# **DRAINAGE LETTER REPORT**

## **NOR'WOOD BIBLE CHURCH LOT 38, SADDLEHORN RANCH FILING NO. 3**

October 13, 2023  
Revised January 15, 2024  
Revised May 9, 2024  
Revised June 28, 2024

**JPS Project No. 042303  
PCD Filing No. PPR2346**

DESIGN POINT	Q5 (CFS)	Q100 (CFS)
D1.1a	0.8	3.5
D1.1b	1.3	4.8
D1.1c	3.9	8.5
CH2	0.9	2.5
D1.1d	4.7	12.9
D1.1	5.4	14.9

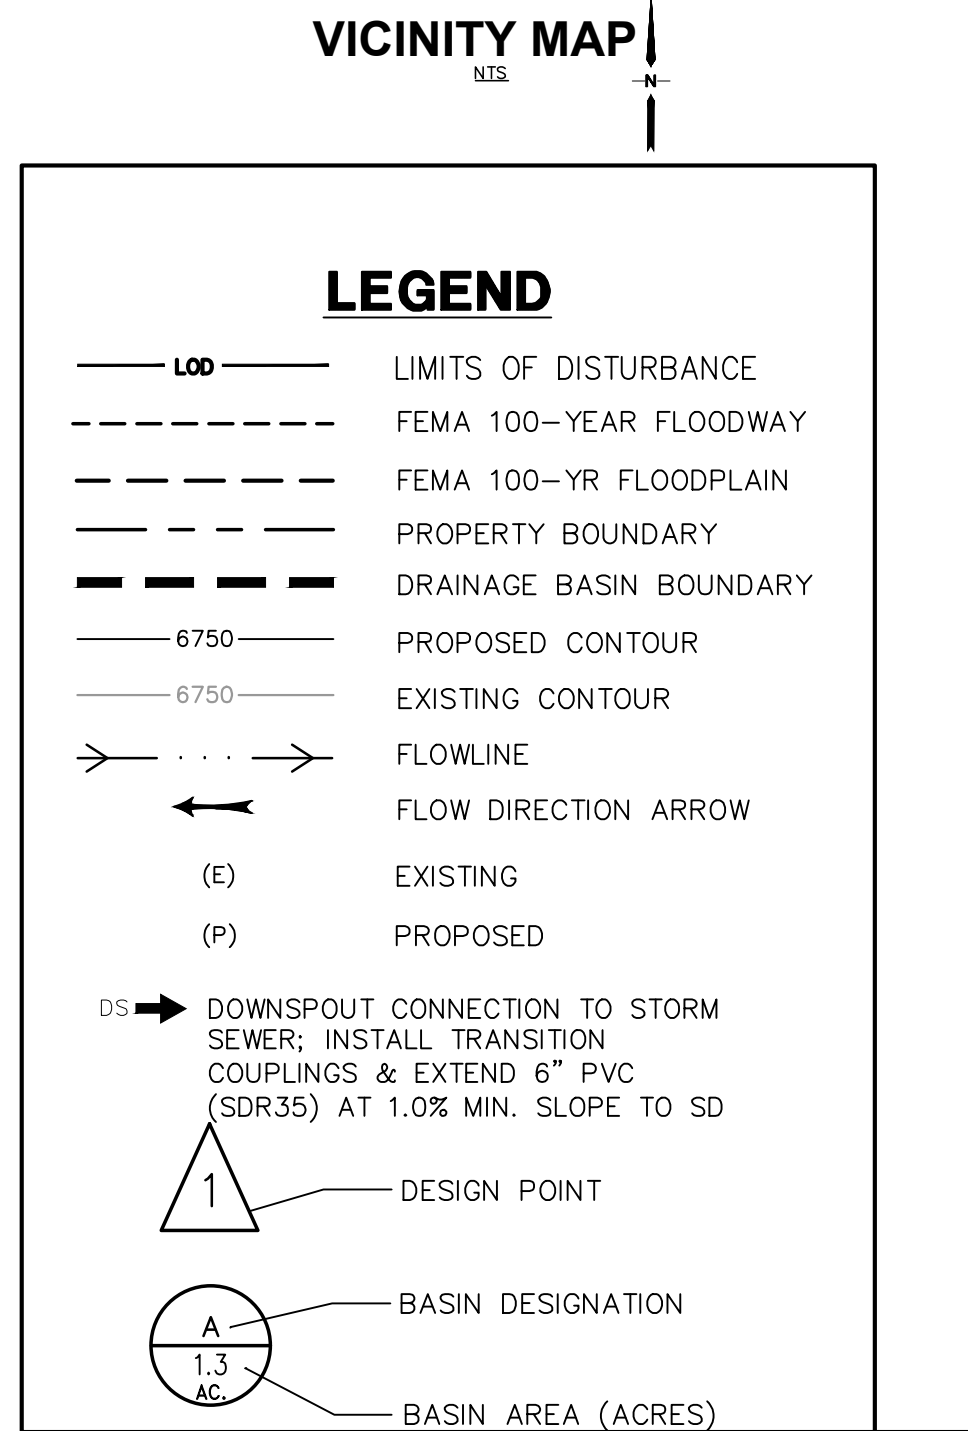
See markup on sheet D1. The culvert at the driveway access is private and maintenance is the responsibility of the property owner.
